**Prince of Wales Hospital - Addition to Approved Acute Services Building (SSD 10339)
Notice of Exhibition**

Thank you for your letter dated 23 August 2019, requesting Transport for NSW (TfNSW) to review and comment on the above.

Figure 3: Proposed ASB Addition showing lowering of Hospital Road (Source: BVN, 2019)

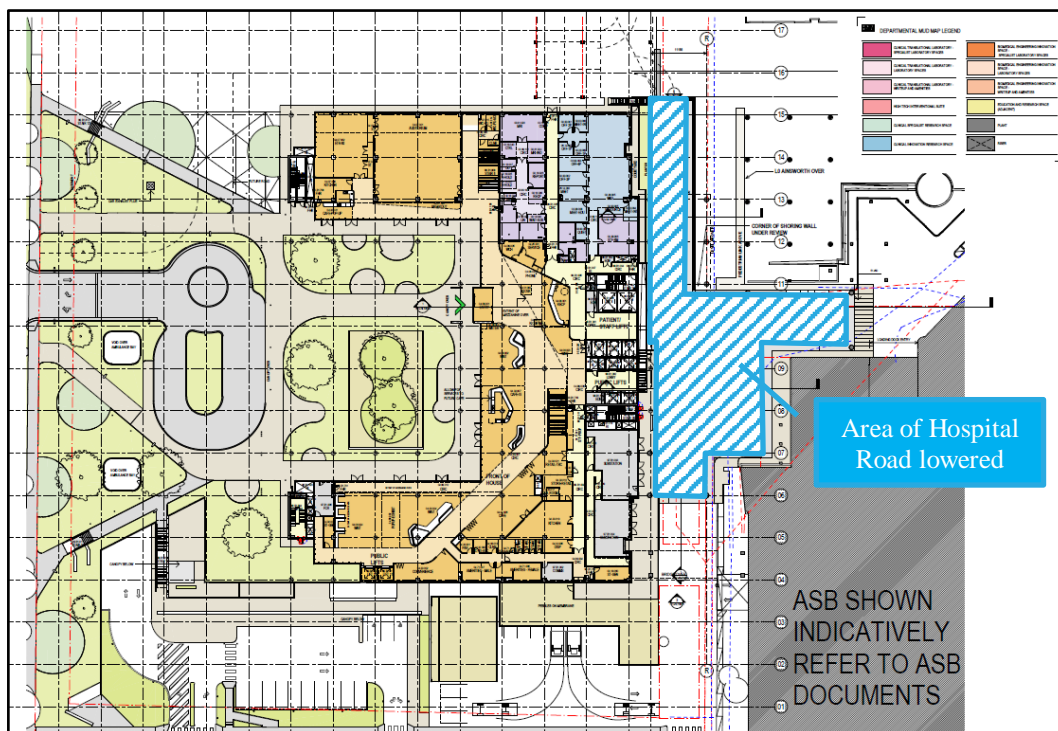
- Hospital Road - Lowering of an 80 m section of the private service road known as Hospital Road by up to 4 m and closure of that private road from its intersection with Barker Street and High Street, save for maintaining vehicular access to the loading dock and staff car park off Barker Street; and
- Magill Street - Open Magill Street to improve traffic network flow around the construction site.

It is advised that the applicant continue to consult with Roads and Maritime Services and the Sydney Coordination Office within TfNSW to identify measures to mitigate any impacts to the surrounding network.

Figure 11: Alternative traffic routes for the closure of Hospital Road at High Street

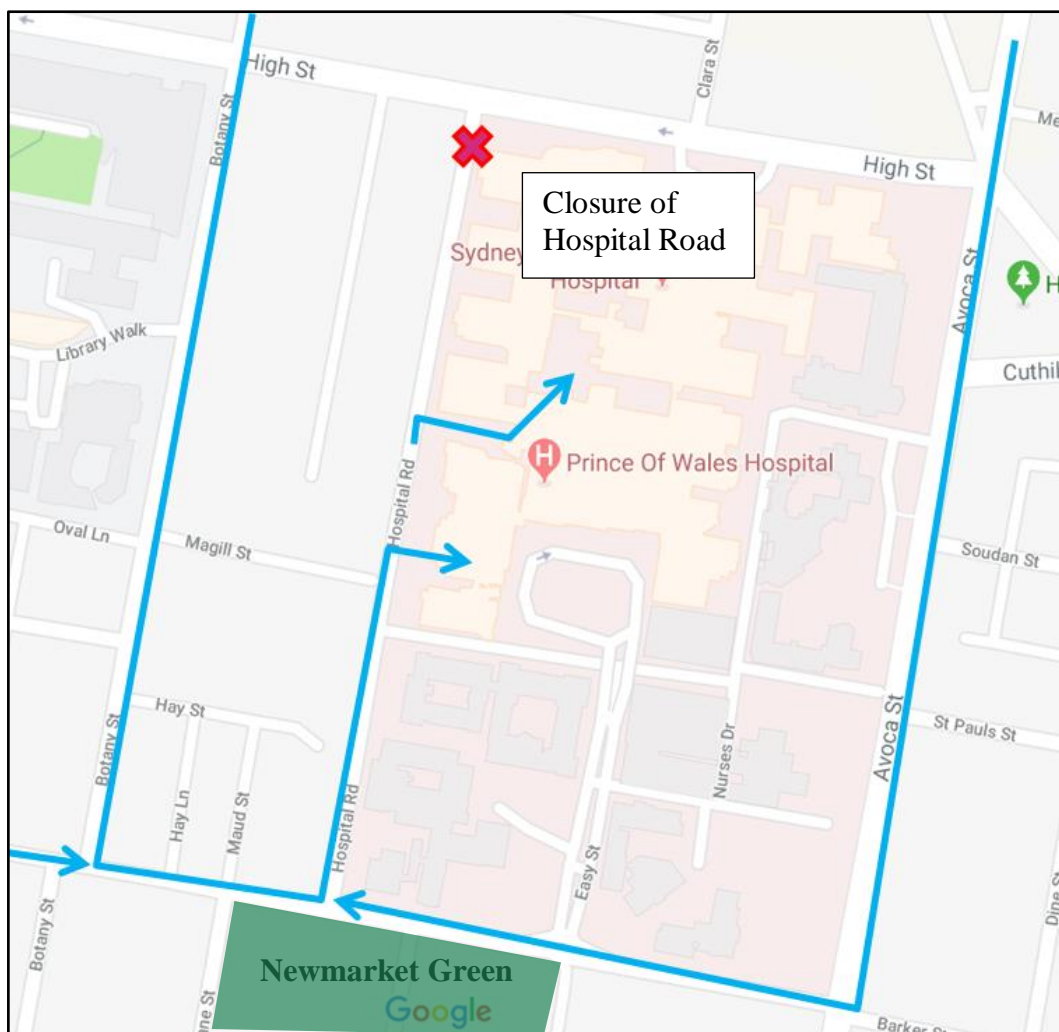
Further, TfNSW advises that the use of High Street by the development's construction vehicles should be avoided to ensure that the interface risk between construction vehicles and the Sydney Light Rail and buses is mitigated.

- Prepare a Construction Pedestrian and Traffic Management Plan (CPTMP) in consultation with the Sydney Coordination Office within TfNSW, Roads & Maritime Services, the Sydney Light Rail operator; and
- Consult with TfNSW, Roads and Maritime Services and the light rail operator at Traffic and Transport Construction Coordination meetings during construction.
